This addendum modifies construction documents issued 09-19-2016 and consists of four different types of content:

Addenda

**C-203**

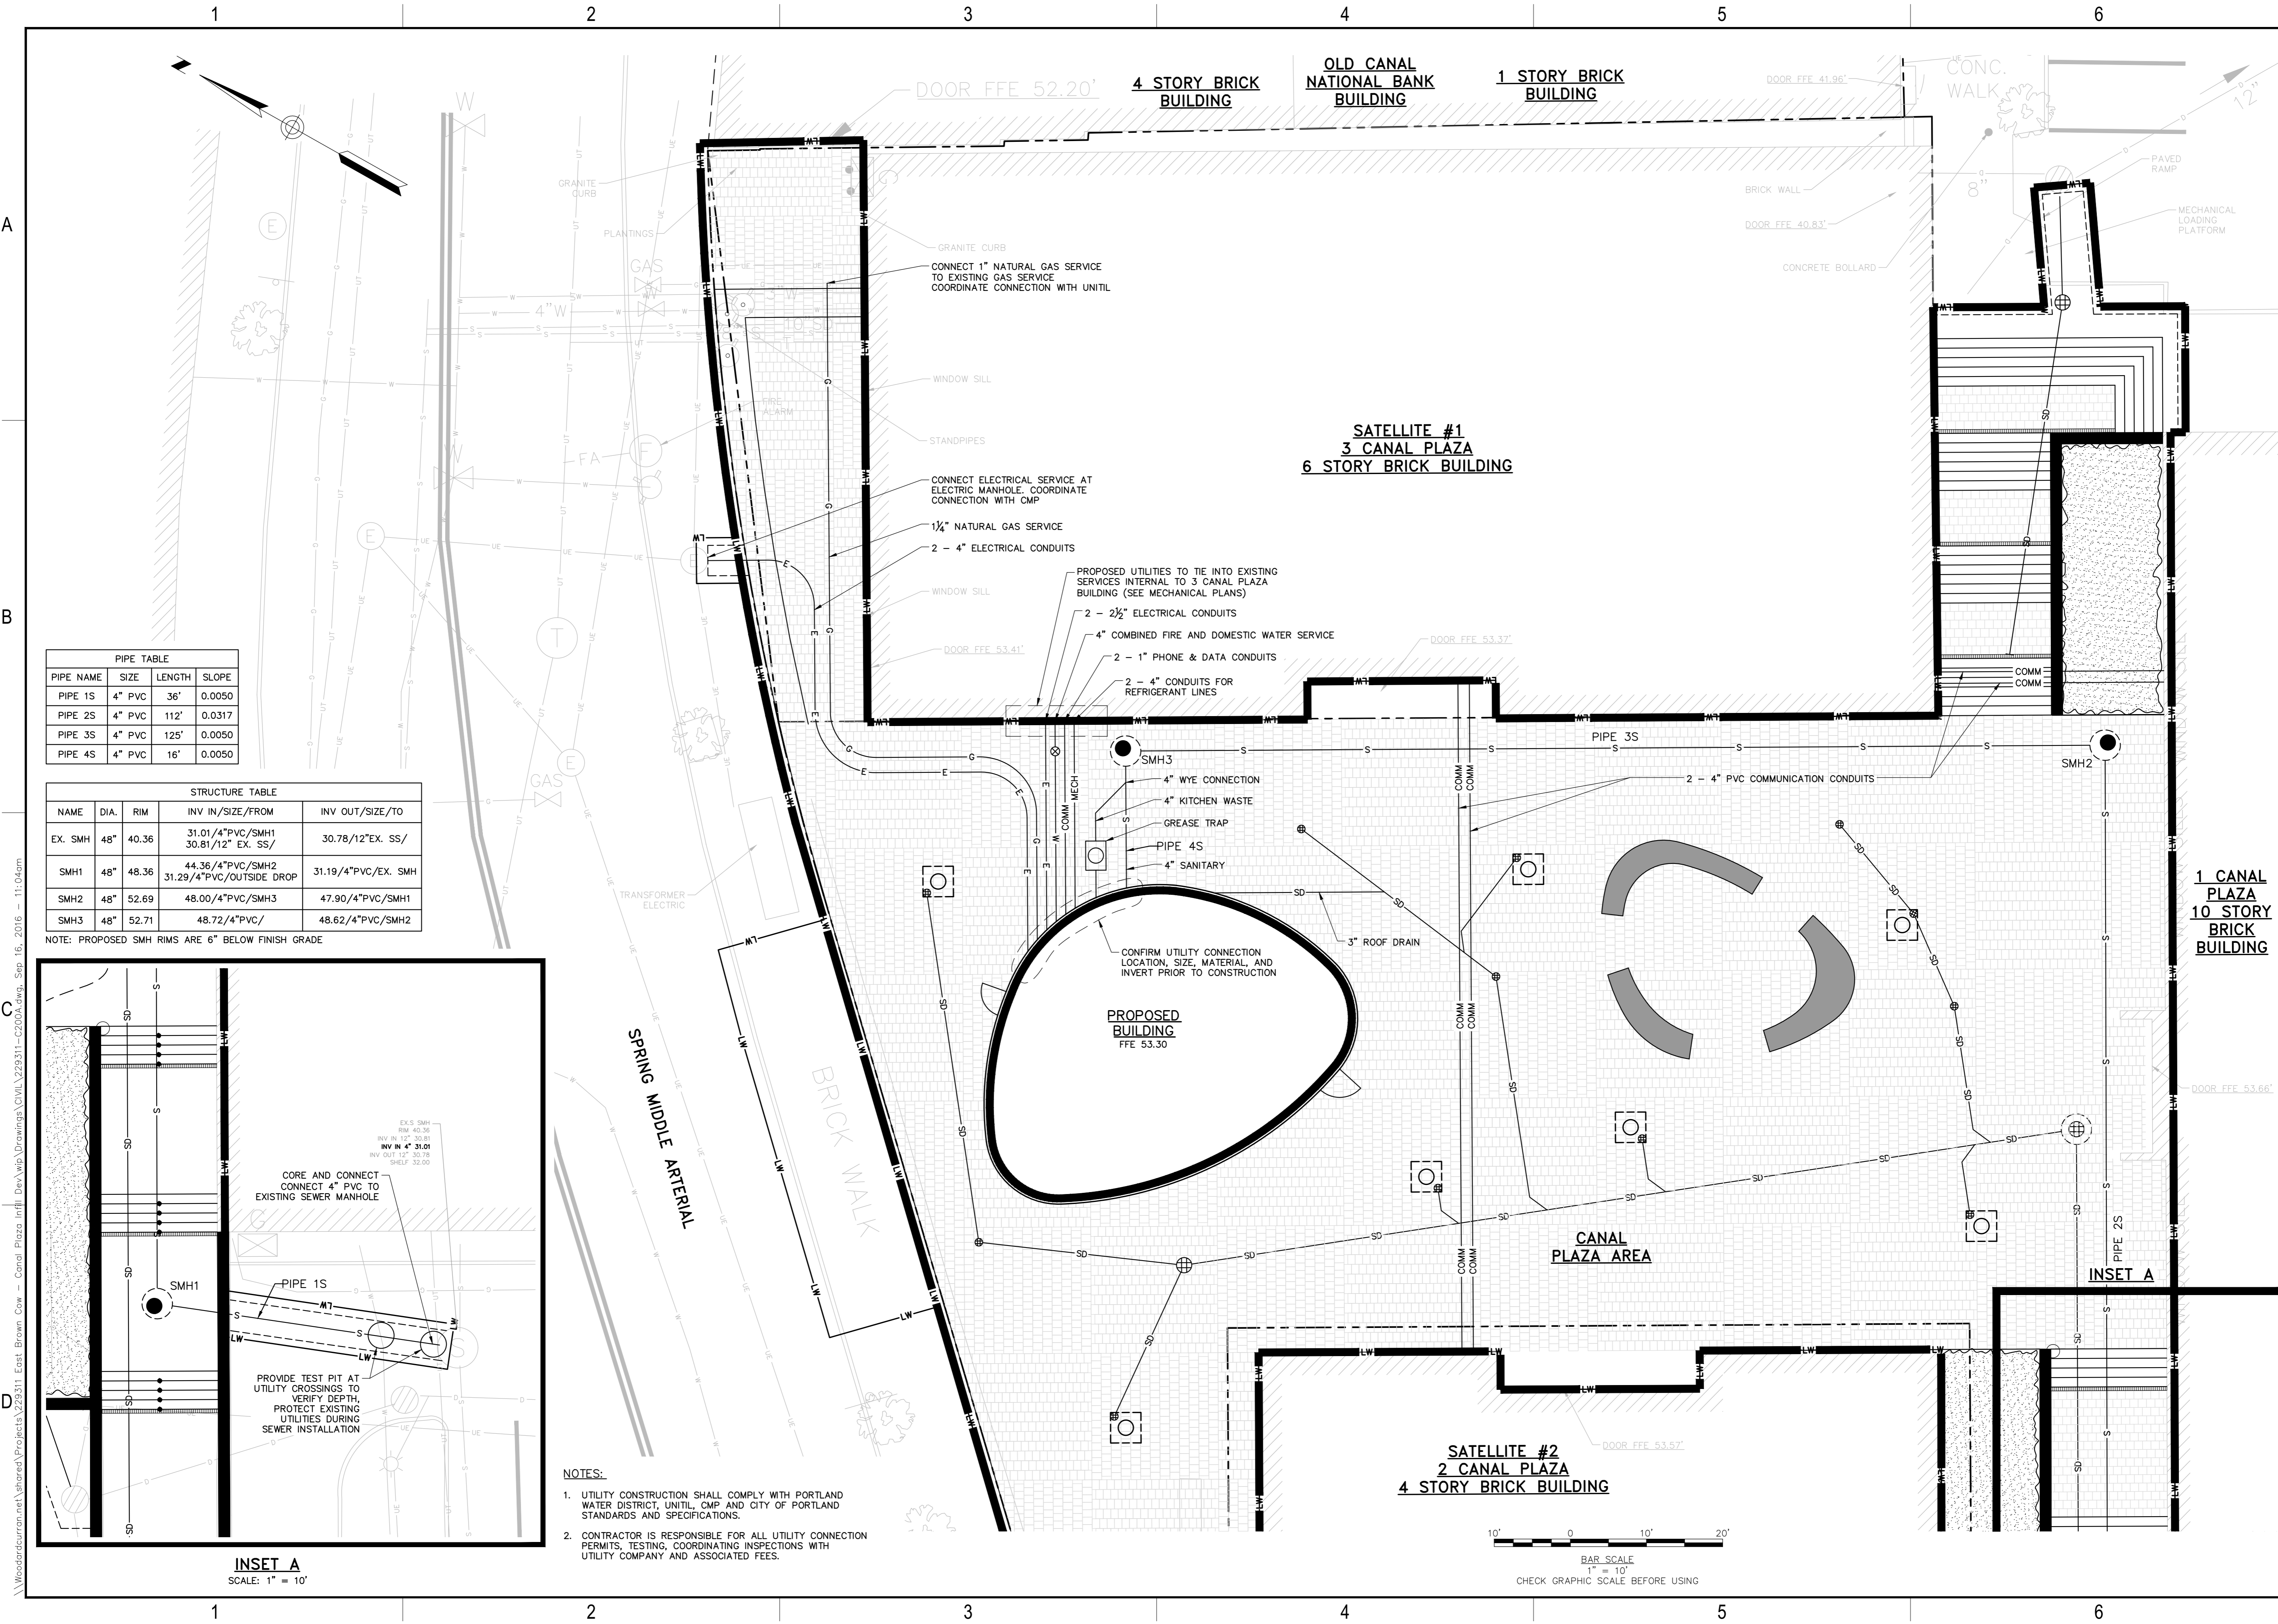
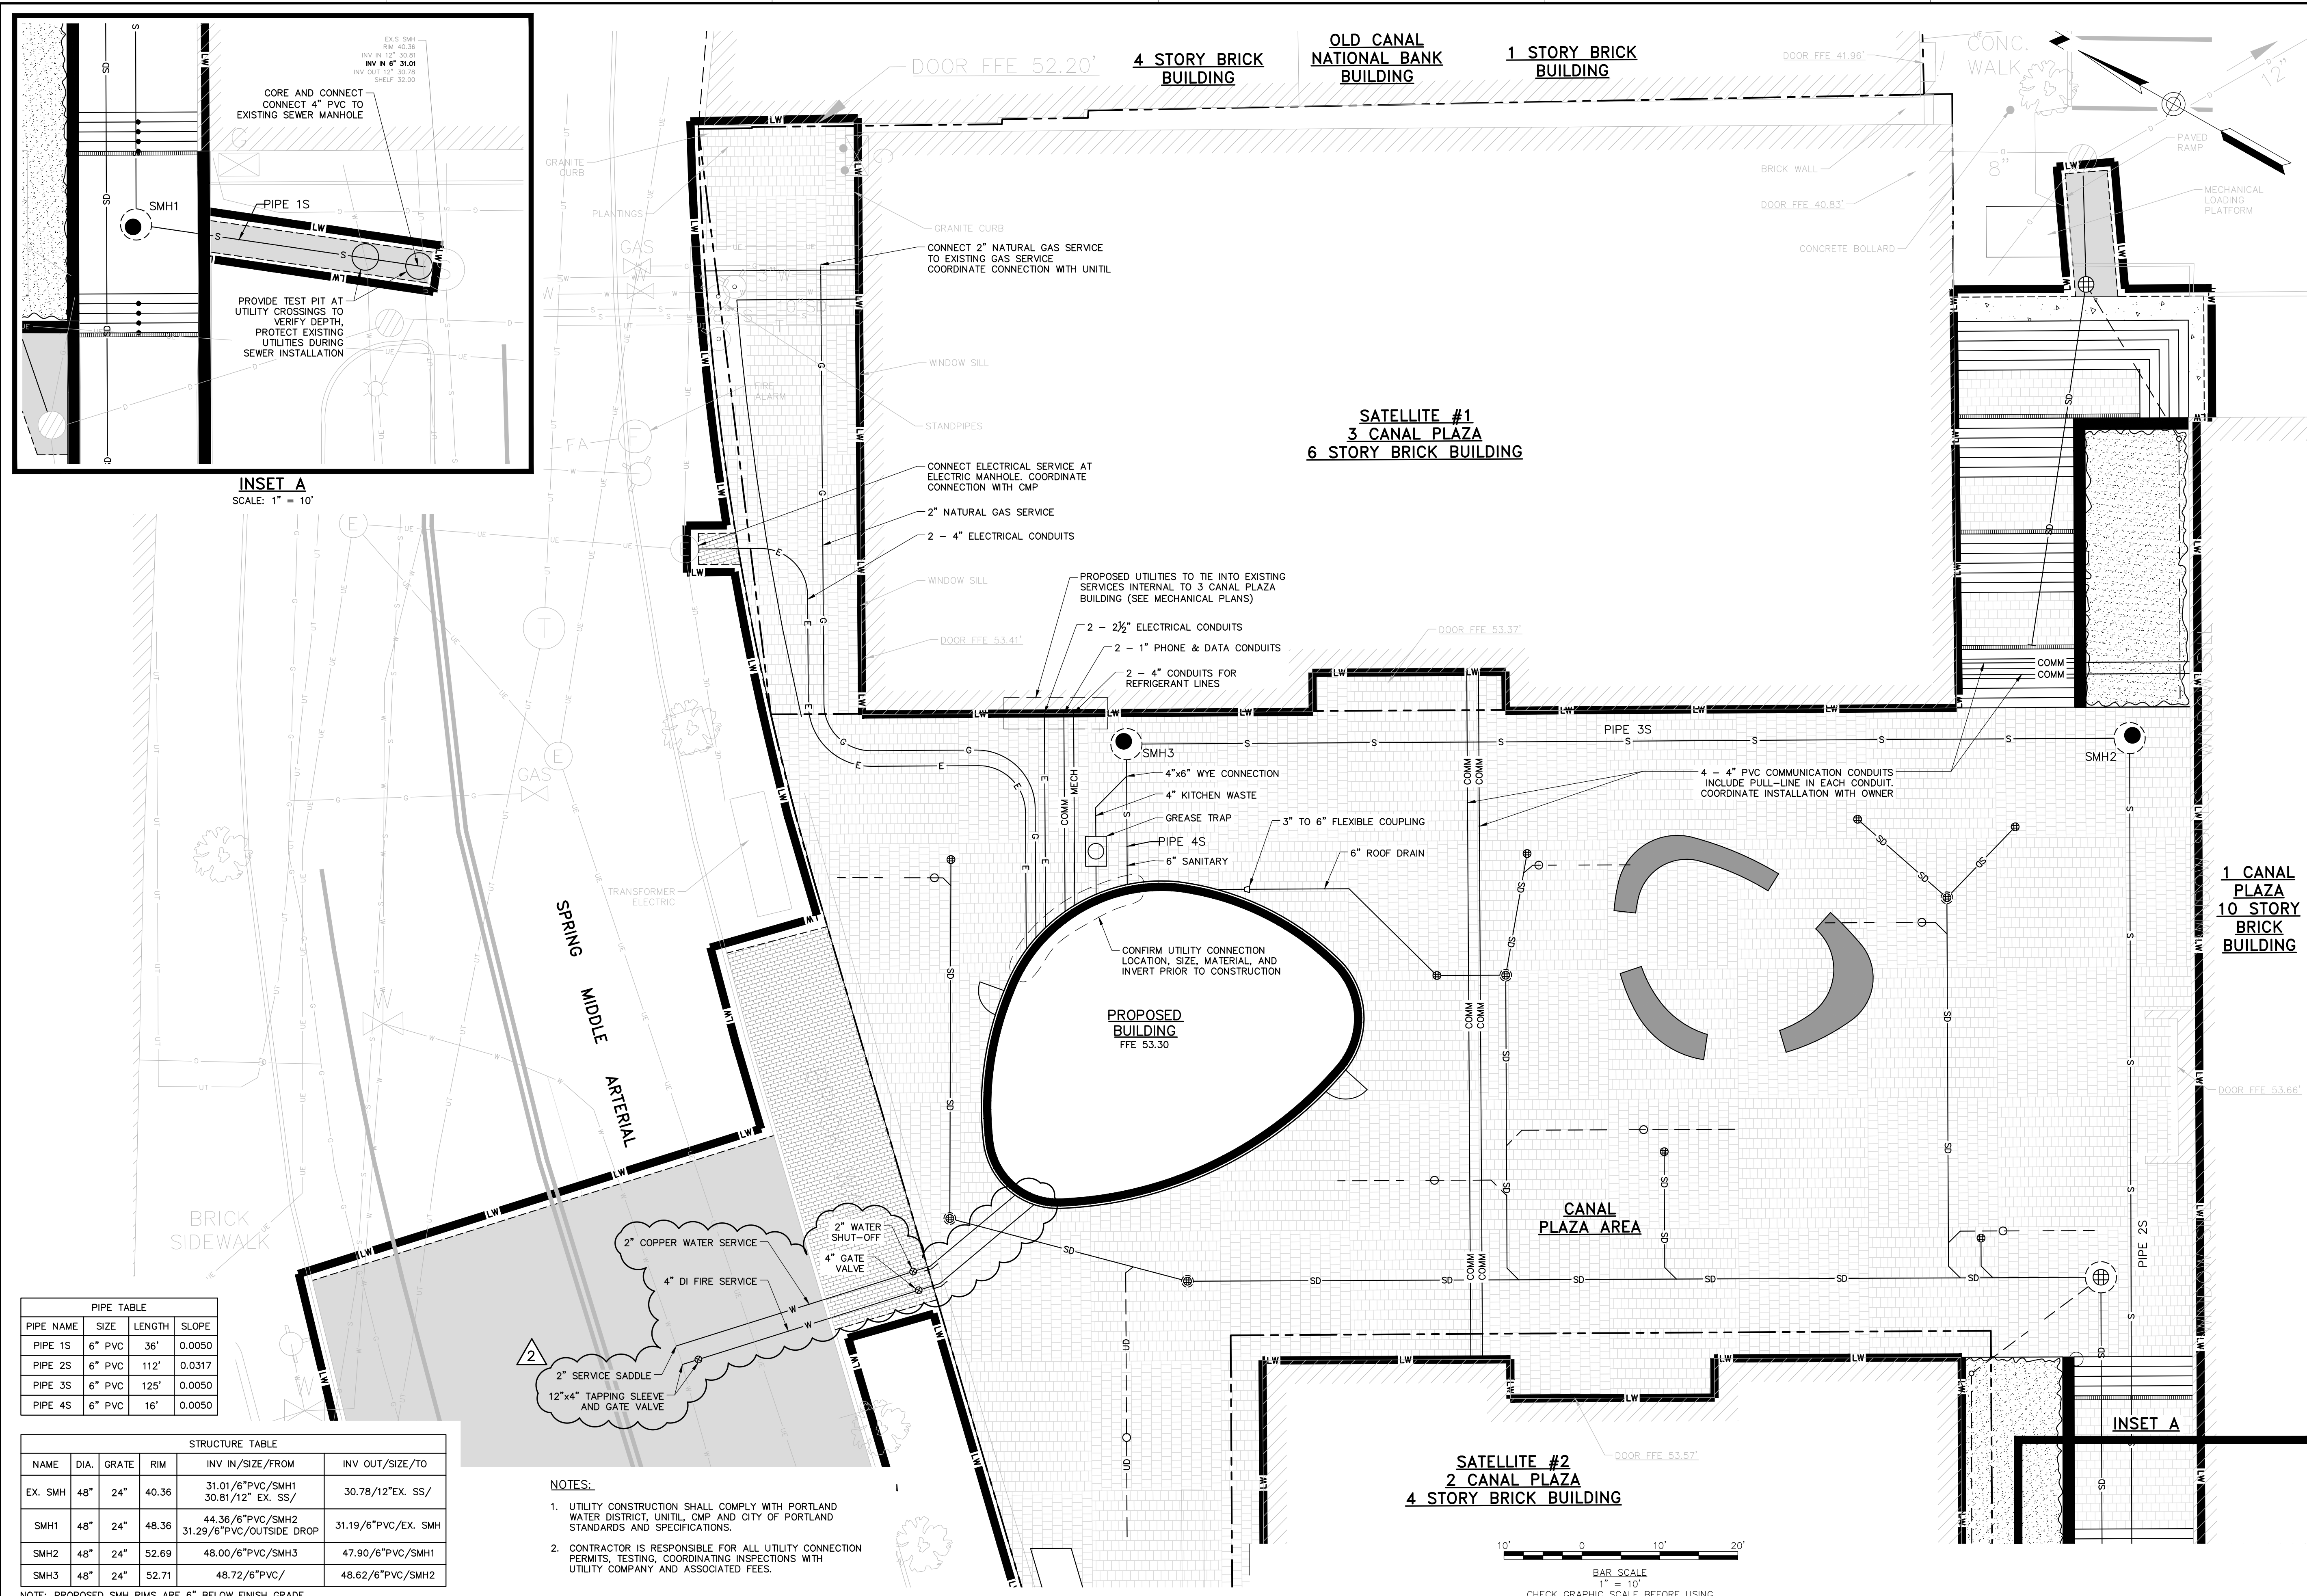
Item#	Type	Reference Sheet / Section	Description	Notes
CIVIL-01	R-SHT	G-001	Reissued	<ul style="list-style-type: none"> • Legend modifications
CIVIL-02	R-SHT	C-100	Reissued	<ul style="list-style-type: none"> • No edits, reissued as complete set for addendum
CIVIL-03	R-SHT	C-200	Reissued	<ul style="list-style-type: none"> • Modified demolition notes
CIVIL-04	R-SHT	C-201	Reissued	<ul style="list-style-type: none"> • Modified tree openings • Modified drainage layout and structures • Added concrete sidewalk repair
CIVIL-05	R-SHT	C-202	Reissued	<ul style="list-style-type: none"> • Changed slot drains to trench drains • Modified drainage layout and structures • Modified tree openings
CIVIL-06	R-SHT	C-203	Reissued	<ul style="list-style-type: none"> • Changed slot drains to trench drains • Modified drainage layout, grading, and structures • Modified tree openings • Corrected Existing CB 1 invert elevation
